Subject: IOZ Design Review – 22 Bramhall (Maine Medical)
Written by: Caitlin Cameron, Urban Designer
Date of Review: Thursday, December 13, 2018

This memo summarizes the applicable design guidelines and staff review for the project at 22 Bramhall Street – Congress Street Medical Building. This project is reviewed according to the adopted IOZ IDP and Regulatory Framework standards.

Fig.5.20 Computer-generated shadow study / Proposed long-term projects on December 21, noon

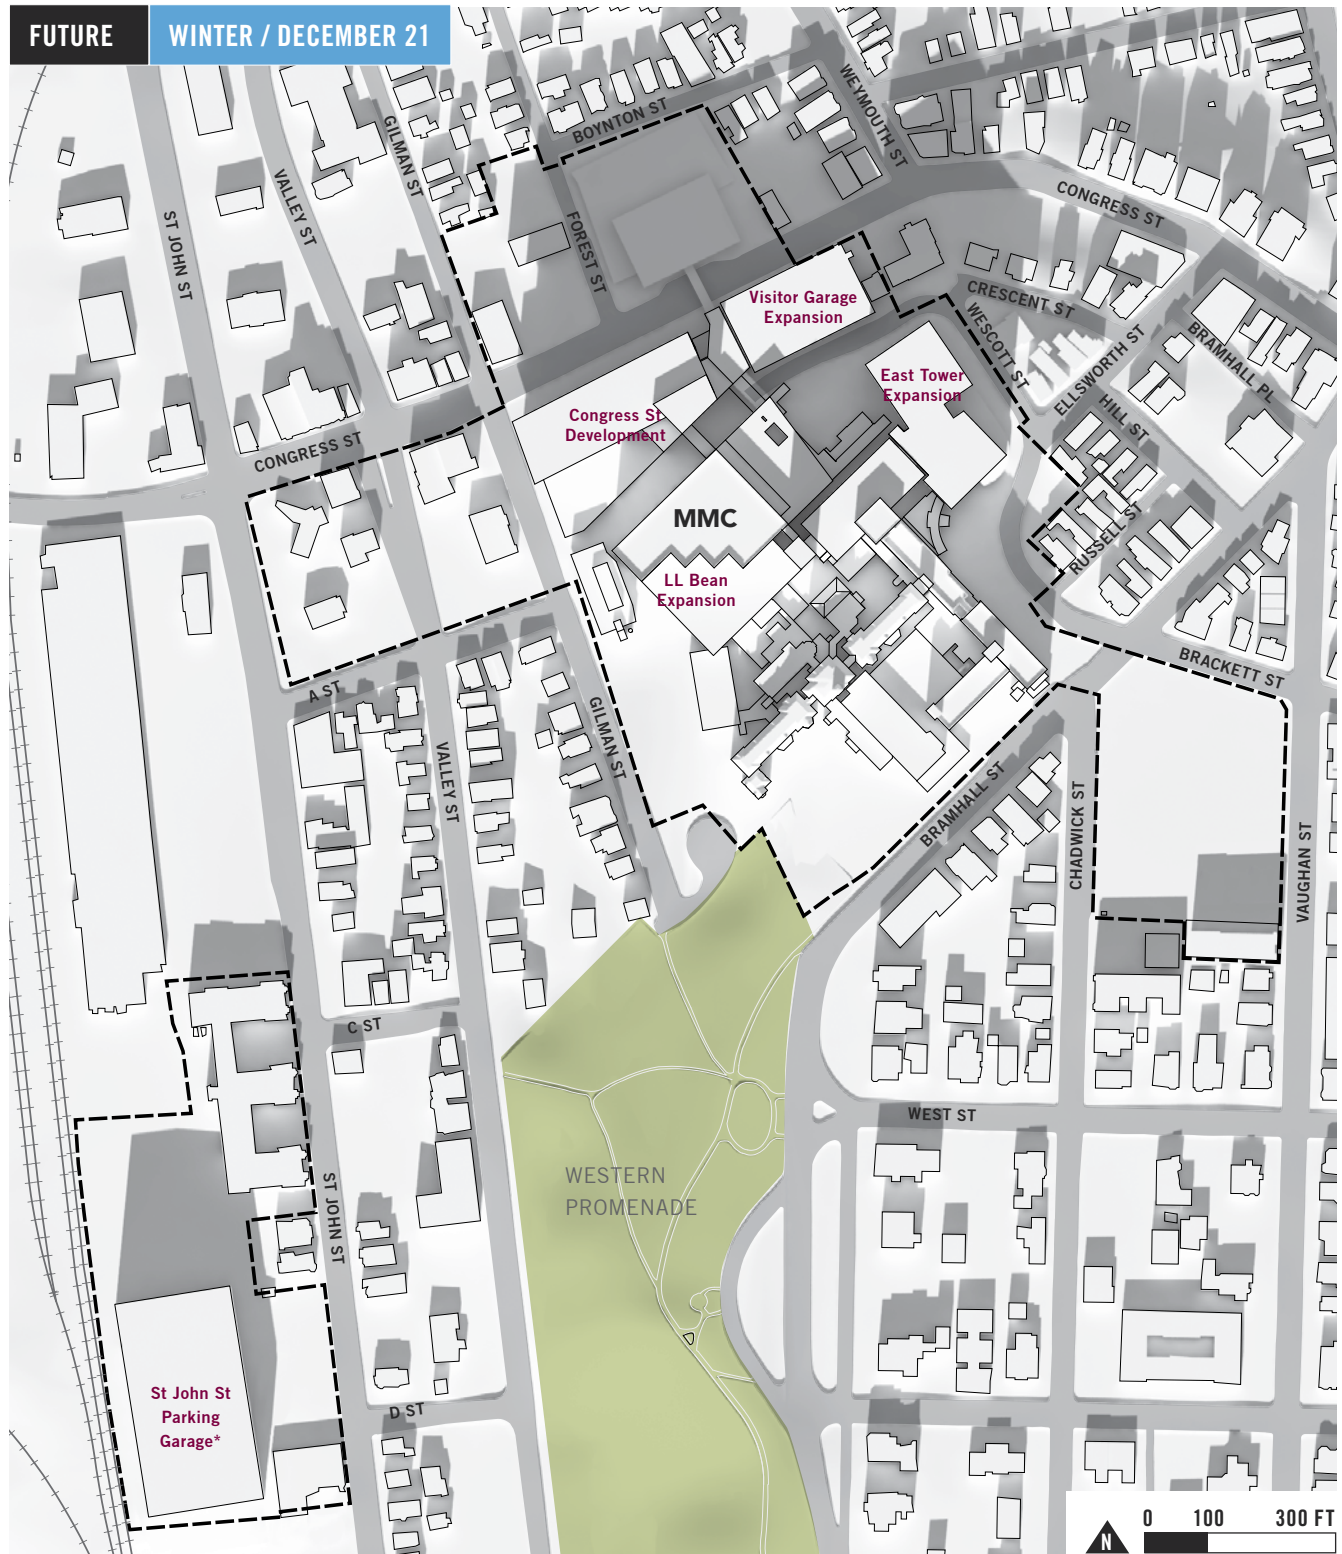
Minimizing Shadow Impacts - Shadow impacts were evaluated as part of the IDP process. The proposed project is shorter but also closer to the street than the existing garage. The impacts as shown in the IDP figures 5.17 through 5.20 show that **additional shadow is created on the street year round and also for one residential building in the winter by this building.**
